App No: P/107/18/DOC

Address: 7 Webb Close Pagham PO21 4XB

Proposal: Application for approval of details reserved by conditions imposed on planning reference P/107/16/PL relating to condition 3 (Surface Water Drainage), 5 (Landscaping) & 14 (External Lighting)

Biard Le Mans Up or Down Outdoor Wall Light

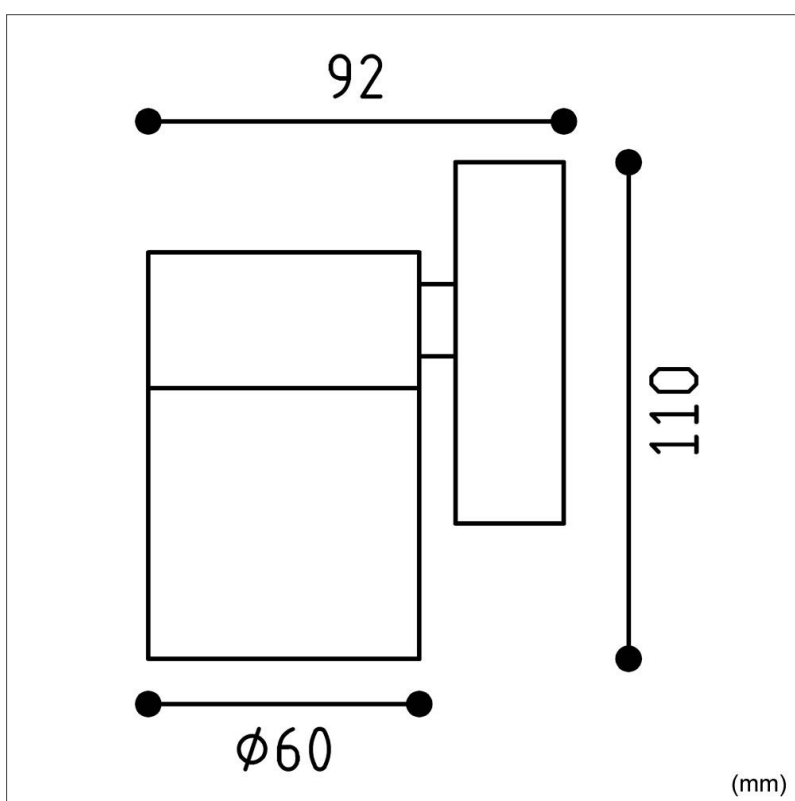
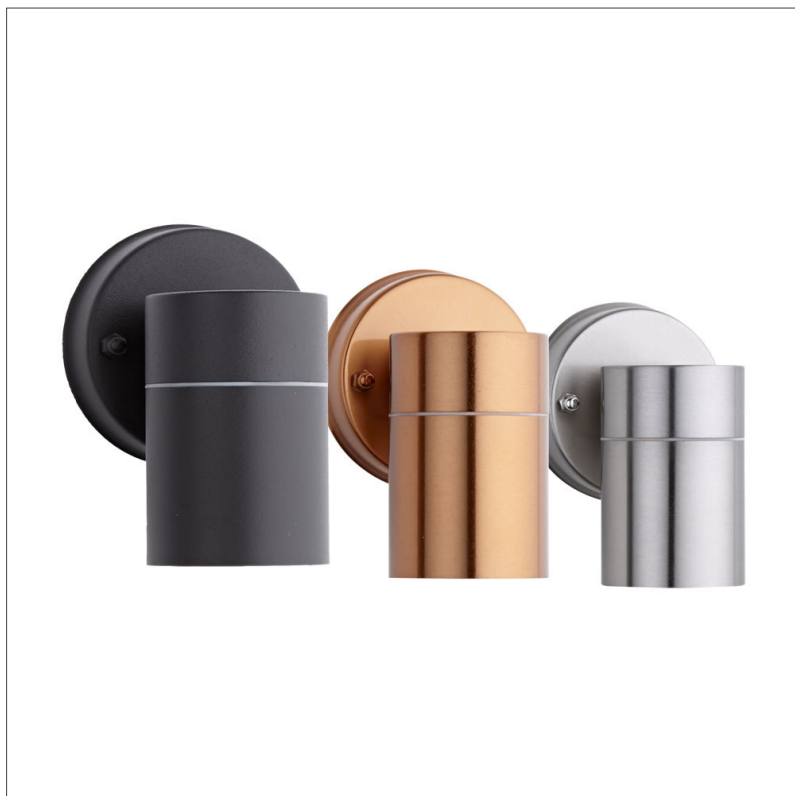
The lighting details which have been provide include lights which can be used for up or down directional lighting. We require that only down lighting is used for the scheme, so the lights will need to be installed to only provide downward lighting.
